**From:** [Connor Armi](#)  
**To:** [Chace Pedersen](#)  
**Cc:** [Guy Moura](#); [Hanson, Sydney \(DAHP\)](#)  
**Subject:** Re: ACU-23-00003 Atlas - Notice of Application  
**Date:** Tuesday, August 8, 2023 11:30:03 AM

This consult is in reference to Administrative Conditional Use application ACU-23-00003 *Atlas*. This undertaking involves the ground disturbing activities of installation of a 100' cell tower with associated concrete footing, the removal of vegetation within the 2500 ft<sup>2</sup> fenced compound and the subsequent replacement with gravel.

**ACU-23-00003 Atlas Tower**

SHEET TITLE:
SITE PLAN

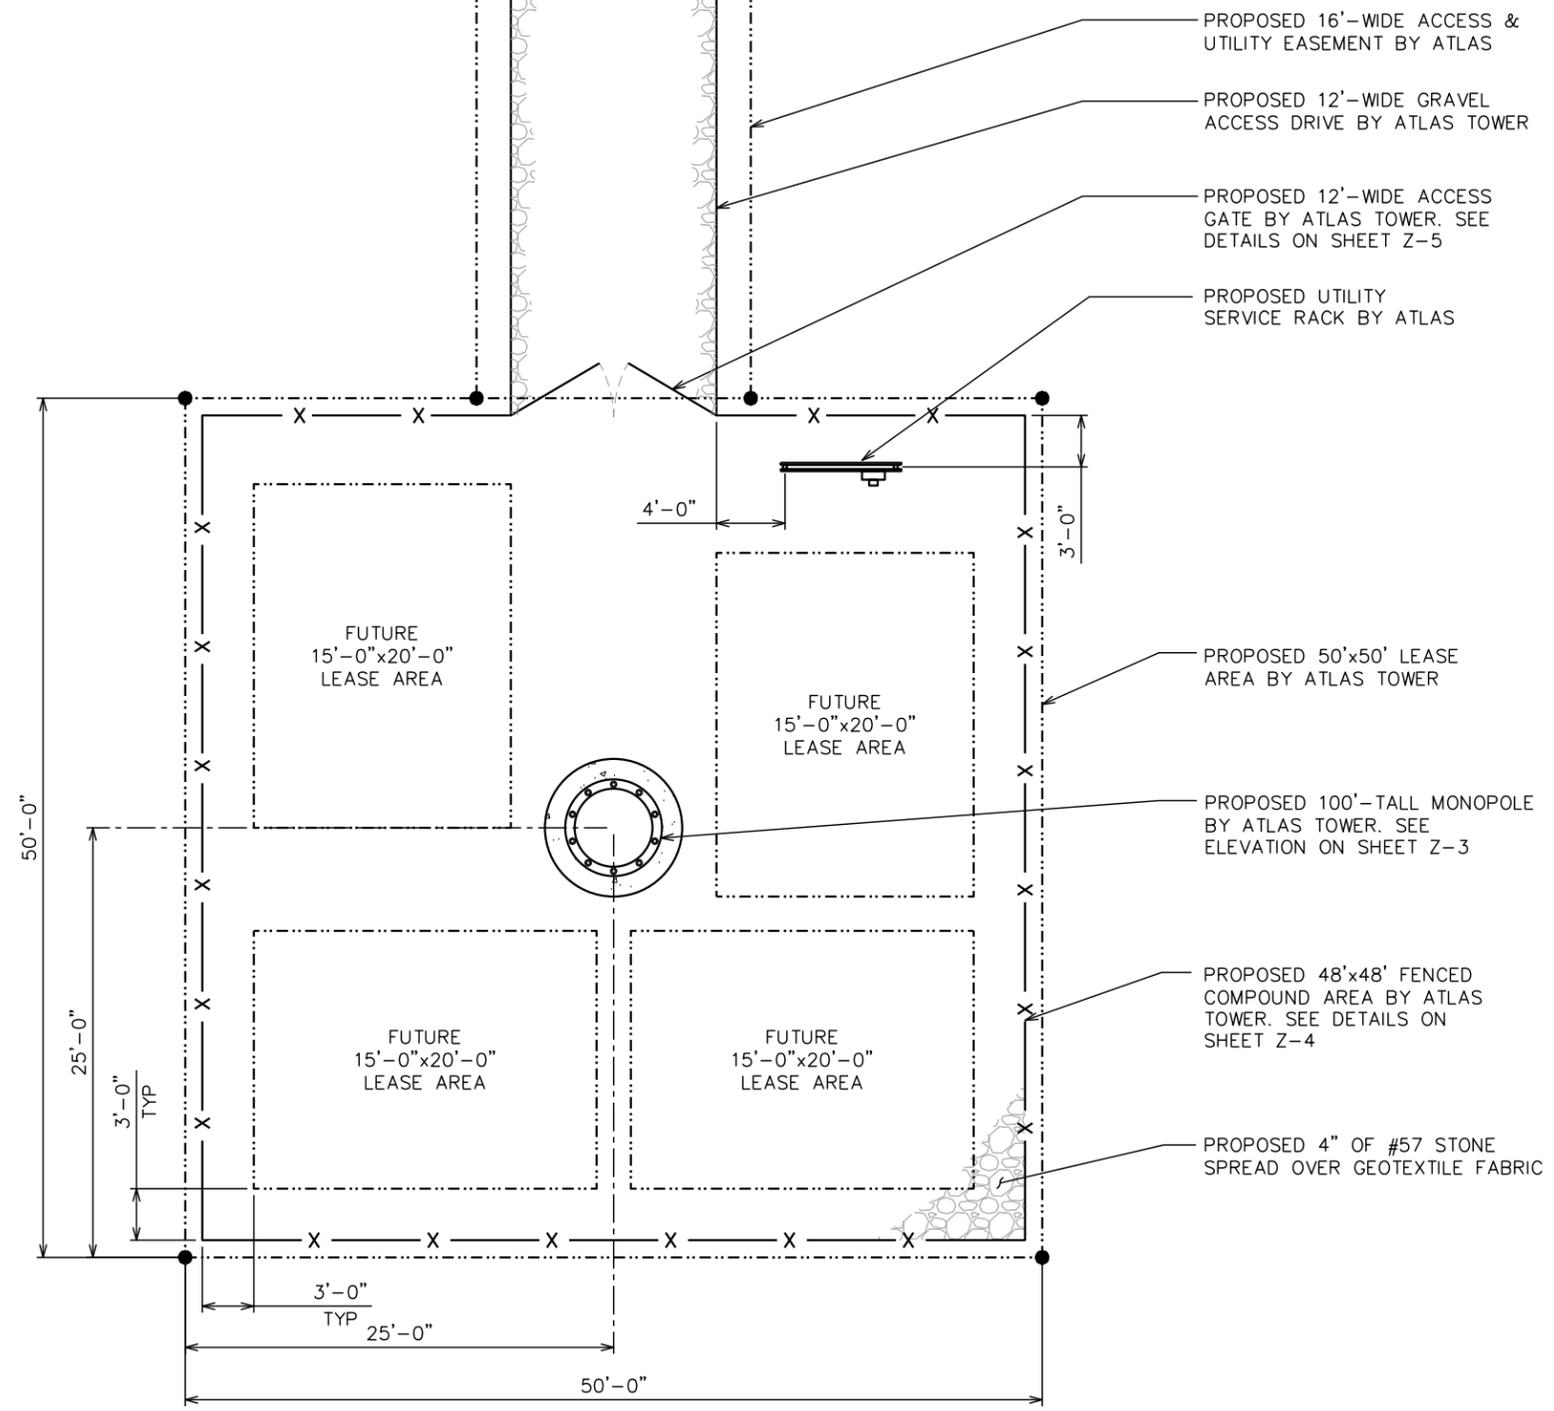
- Addressing for facility must be visible from both directions of travel on Manastash.
- Access road, including turn-around will need to be Appendix D compliant.
- A KVFR Knox lock/box will have to be installed to provide access for KVFR.
- Strongly encourage fire resilient landscaping.

Furthermore no consideration has been given to alternative sites. Victor Strand owns the 20 acre parcel contiguous which includes the 4 acre proposed site. There is adequate space to relocate the proposed tower in the SW or SE corners or even the NW corner of the 20 acre parcel. This would greatly mitigate the problem of distance and sights from nearby residences since the only buildings near the SW and SE corners are barns.

Additionally, there is an existing driveway which would accommodate access to the SW or SE corners and would eliminate the need for an additional driveway on Manashtash Road.
